Subject: CPHR Advice – Environmental Impact Statement – Project Mars Data Centre (SSD- 82052708) (Lane Cove)

CPHR has reviewed the *Project Mars Data Centre – 12 Mars Road, Lane Cove West Environmental Impact Statement* (Urbis, March, 2026) and supporting studies and provides its comments at **Attachment A**. In summary,

CPHR Advice – Environmental Impact Statement – Project Mars Data Centre (SSD- 82052708) (Lane Cove)

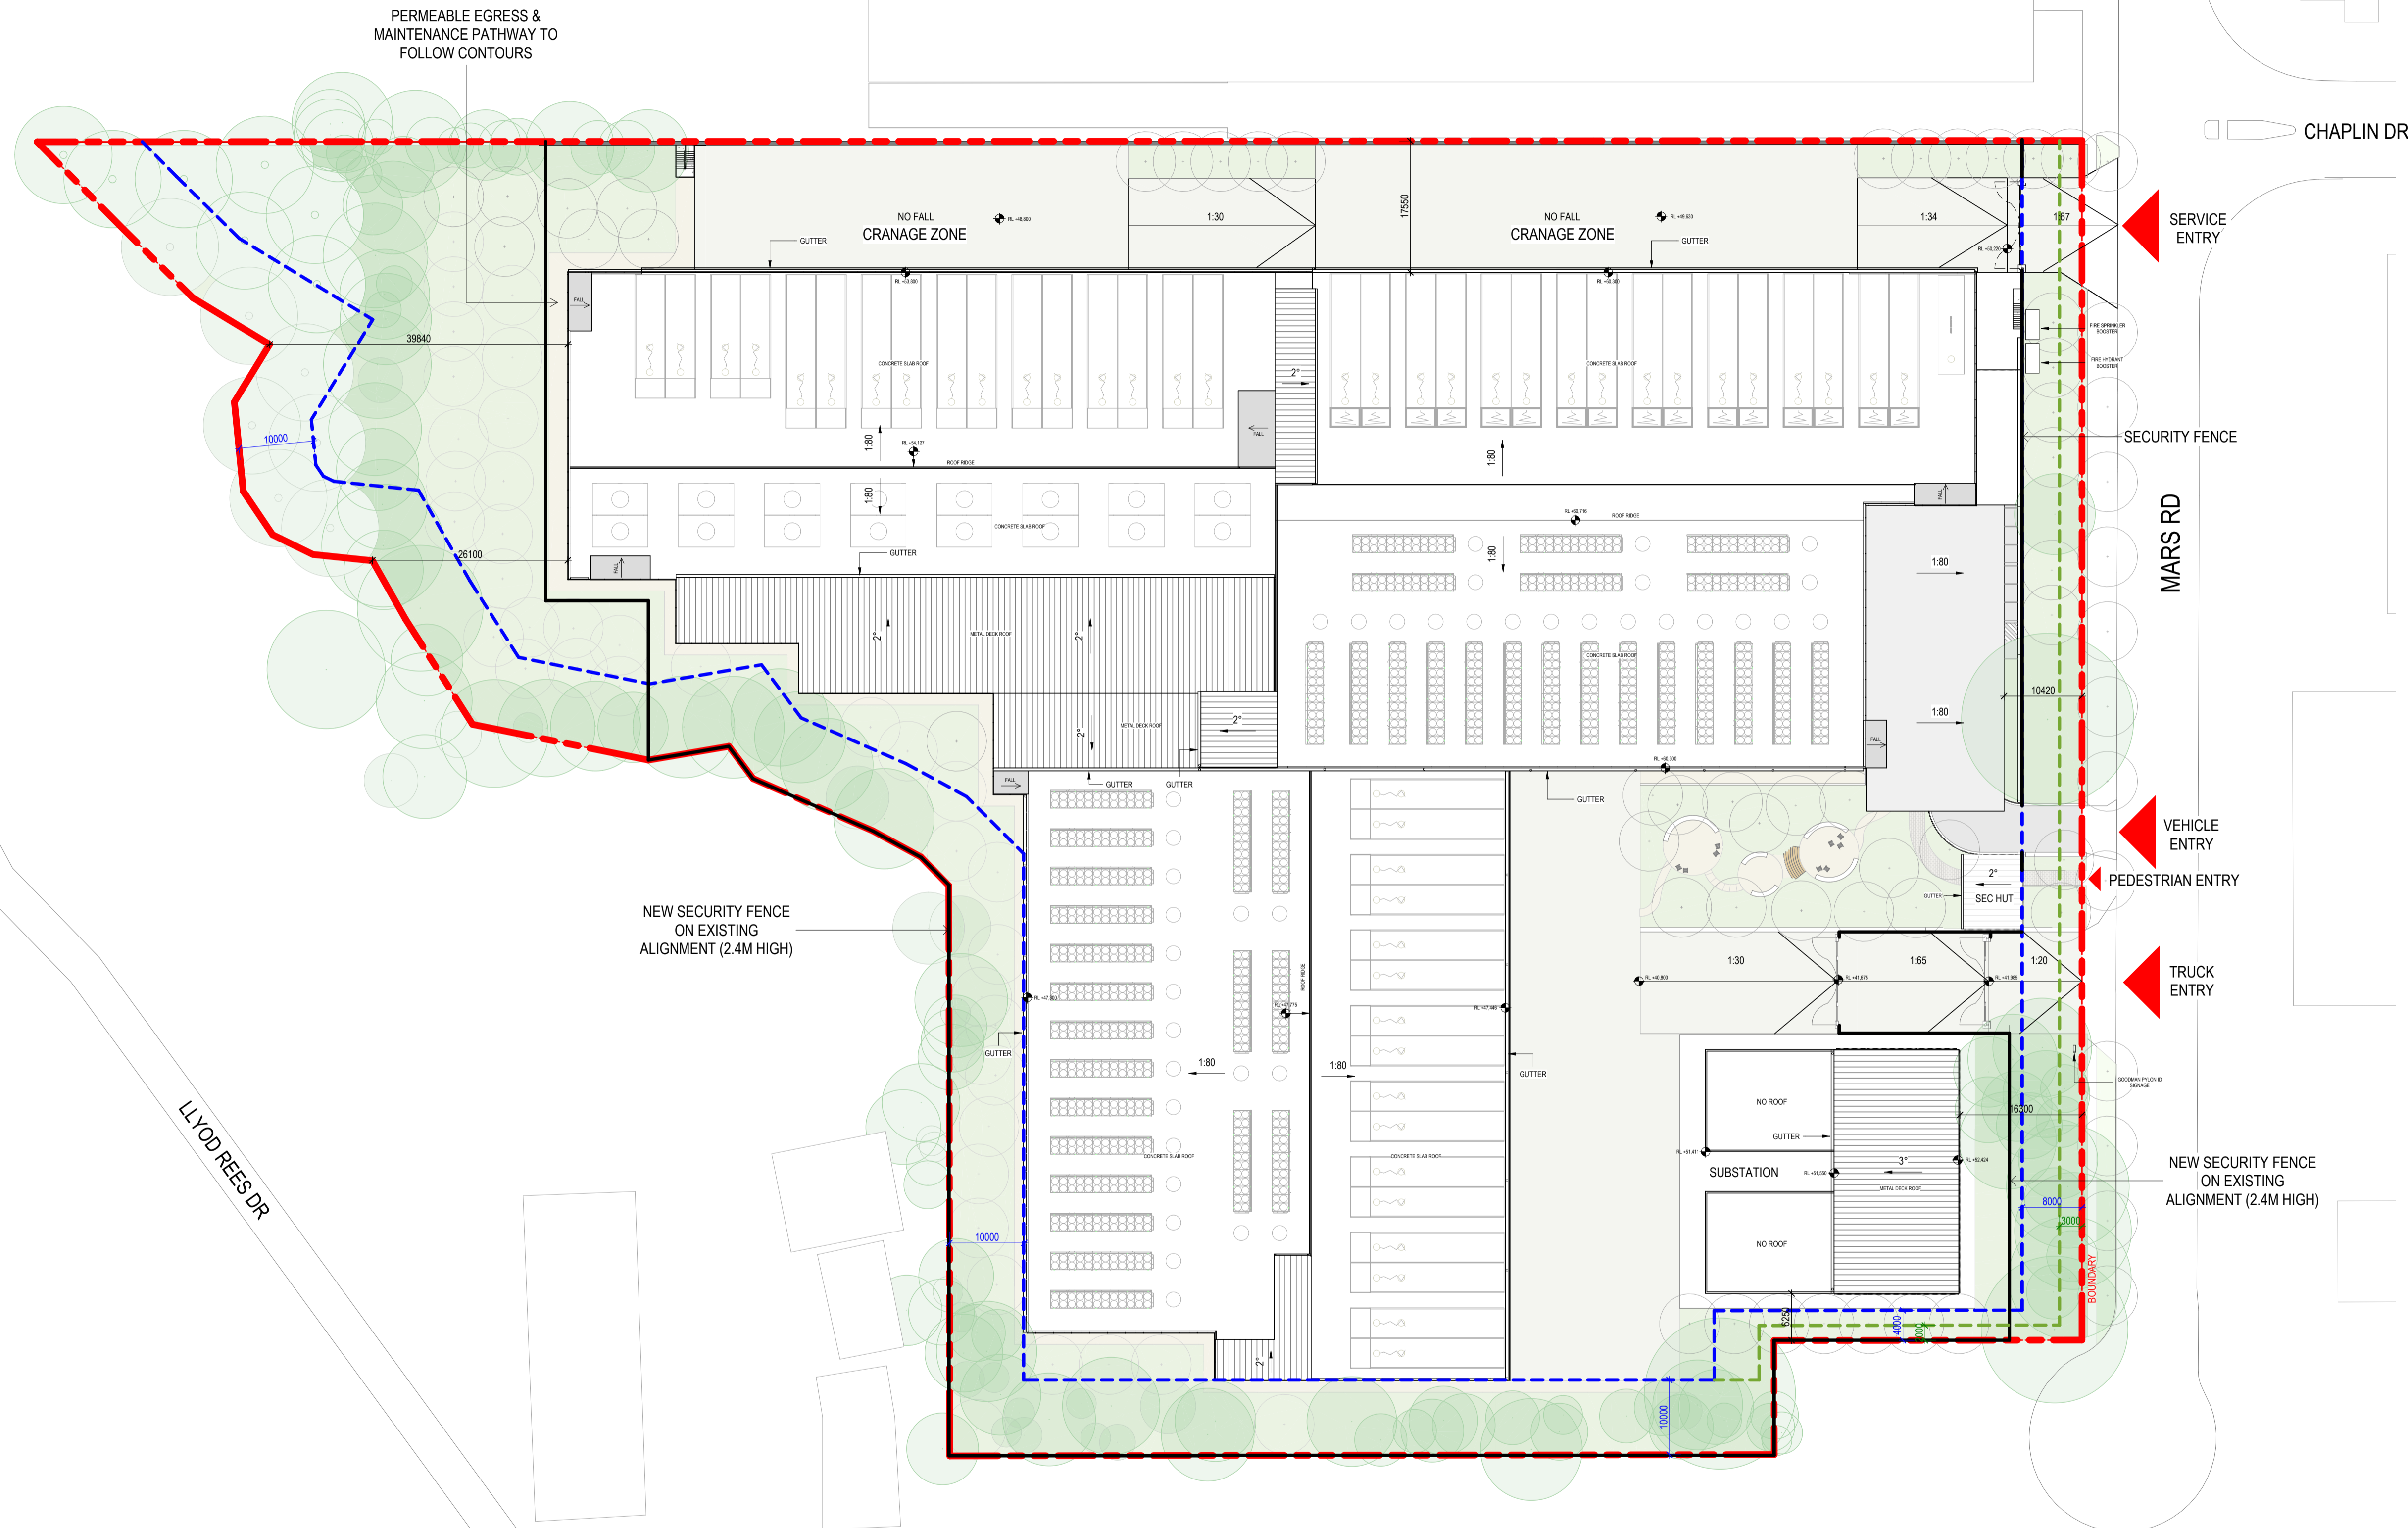
4.	<i>Plans reflecting AIA requirements</i>	The AIA specifies a number of measures intended to assist in the viable retention of trees, but these measures are not reflected in the plans. Recommended action: All measures specified in the AIA are to be clearly shown on relevant plans, including, but not limited to the recommendations outlined in Section 7.3 of the AIA which include construction of the concrete truck entrance (avoiding excavation within the TPZ), hand and/or light weight machinery removal of stairs, construction of permeable path of eastern boundary without construction machinery, and so on.
	<i>Extent and Timing</i>	Pre-construction
